From: Kylie O'Brien Pratt <Kylie.O'BrienPratt@transgrid.com.au>
Sent: Wednesday, 12 July 2017 4:27 PM
To: Thomas Piovesan
Cc: Kenson Ho; Easements&Development
Subject: TransGrid comments 2017-118: Section 96(2) modification application- Cold Storage Facility, Marsden Park, Blacktown (SSD 6799 MOD 1)
Attachments: SSD 6799 MOD 1- Notification of mod_ Transgrid (2).pdf

TransGrid has no objections to the proposed modification, provided that the previously approved buffer around TransGrid's structure is maintained.

1 ELEVATION PARALLEL WITH EASEMENT
96-0-651 1:300

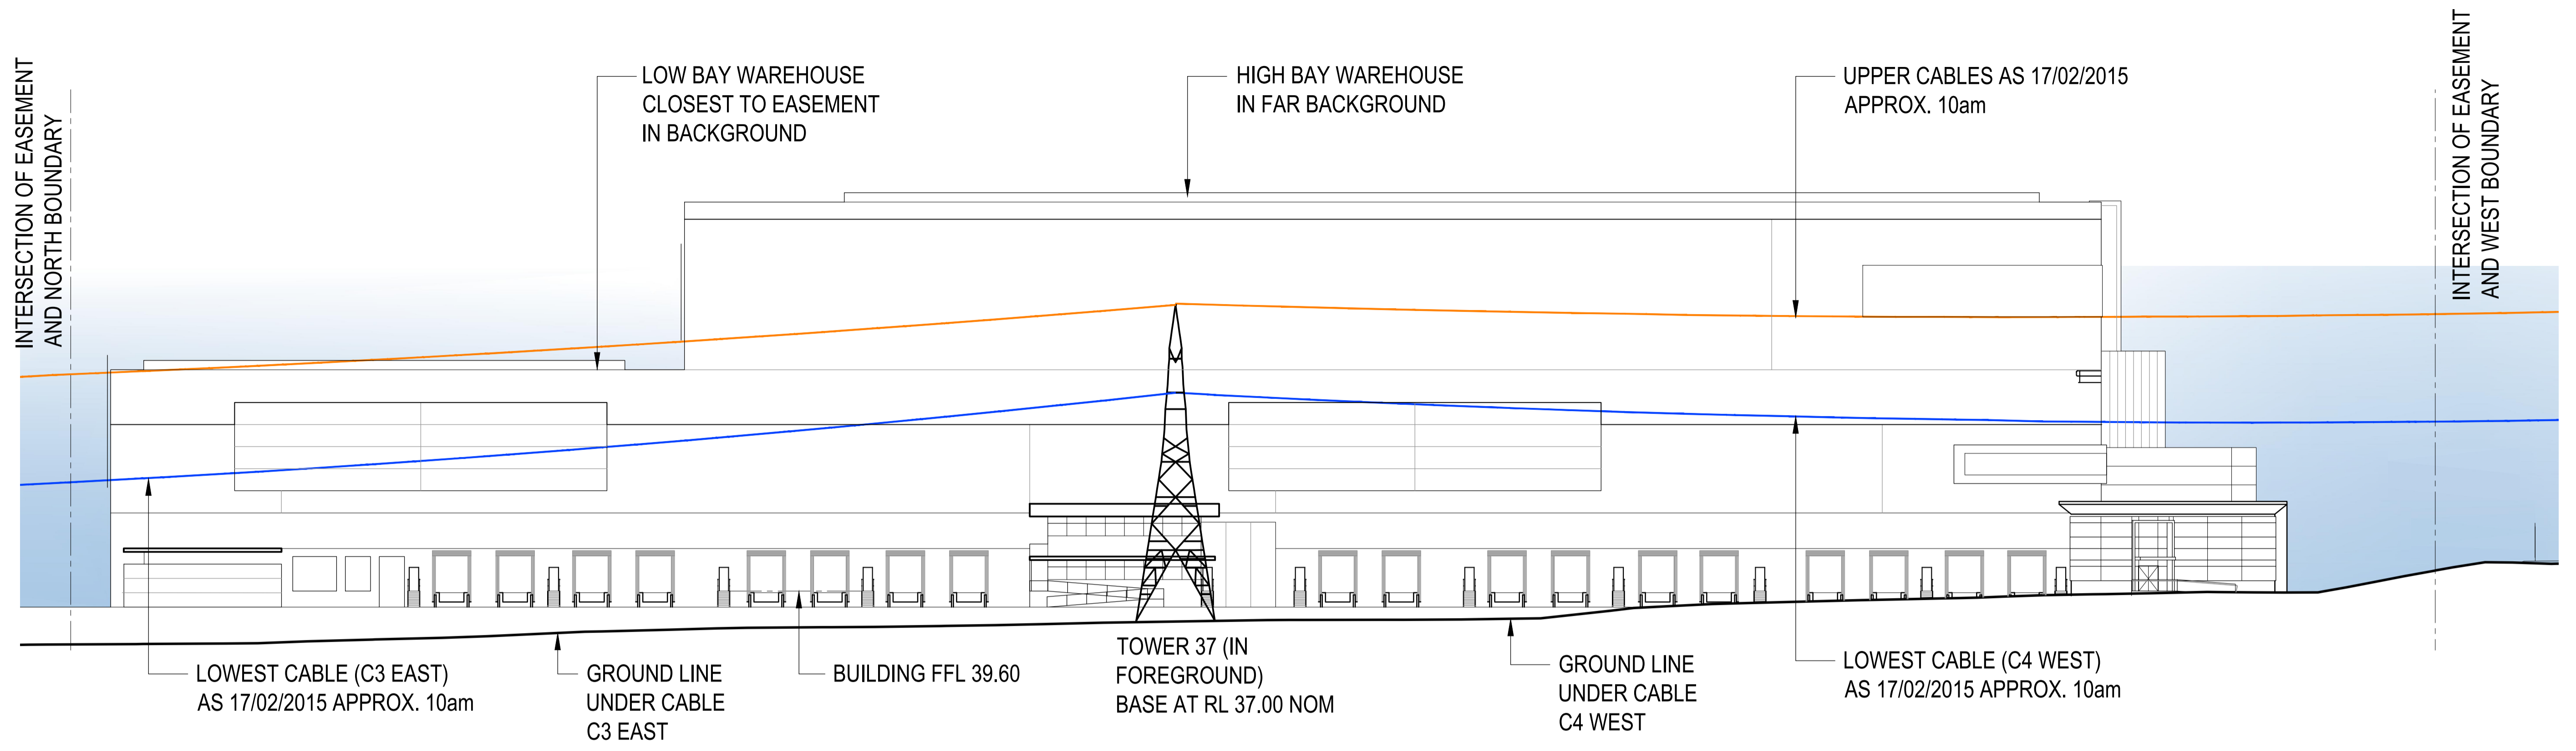
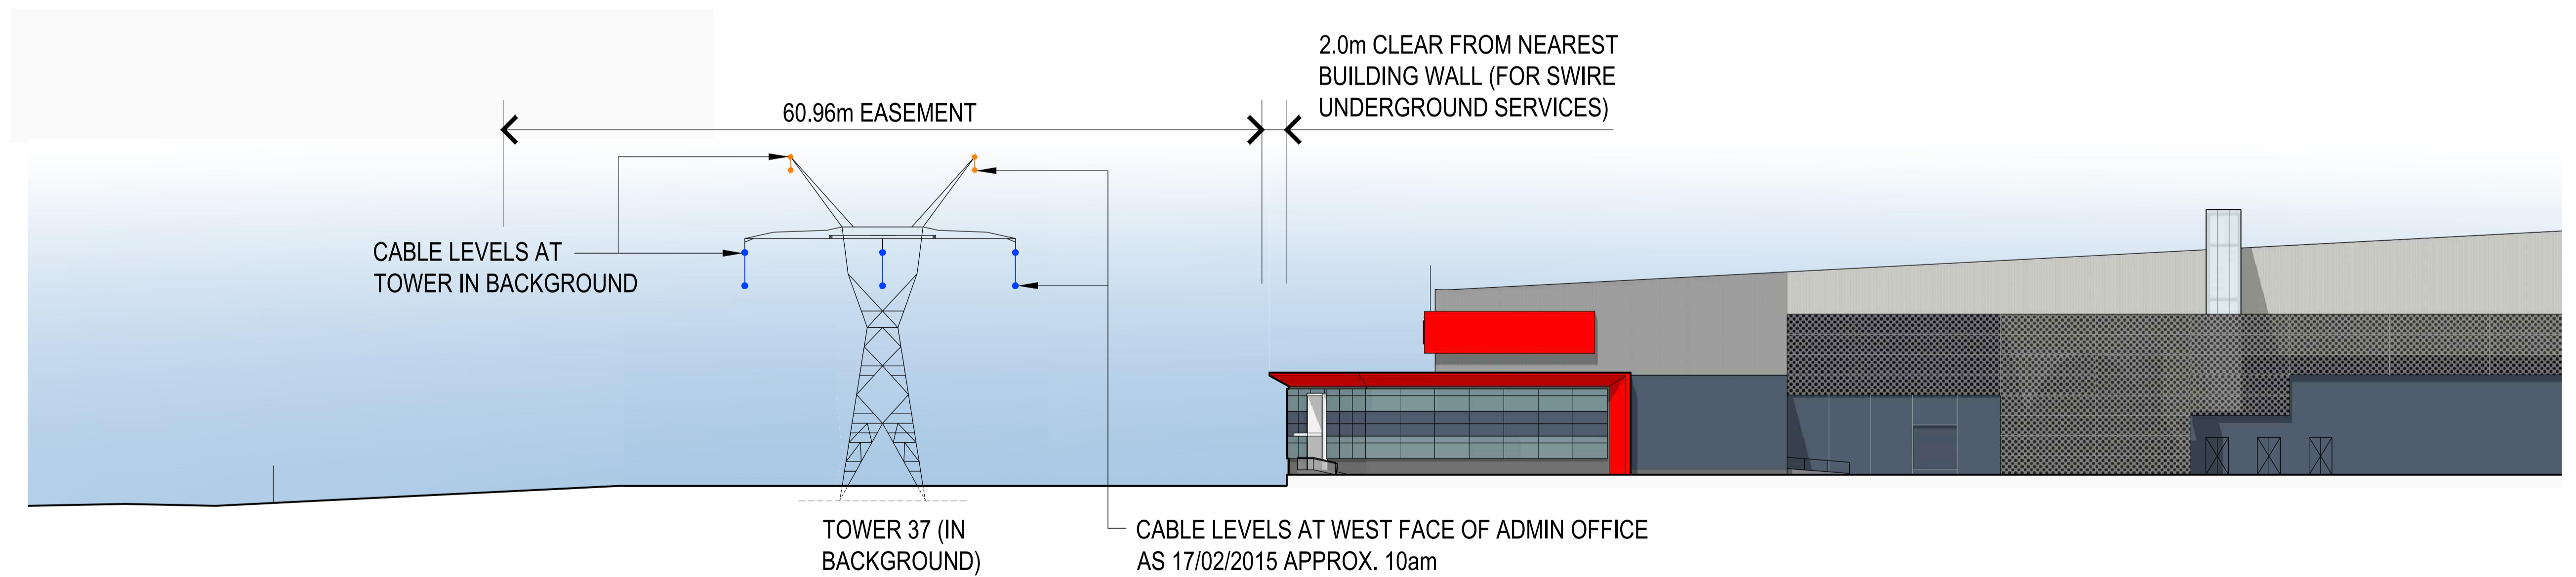
If the proposal includes a change to the previously approved ground level within TransGrid's easement that would result in a reduced vertical clearance distance to the transmission lines then a technical assessment will be required to be undertaken by TransGrid to ensure that the AS7000 safety clearance distance requirement is met. Compliance with the clearance distance requirement is necessary to ensure public safety.
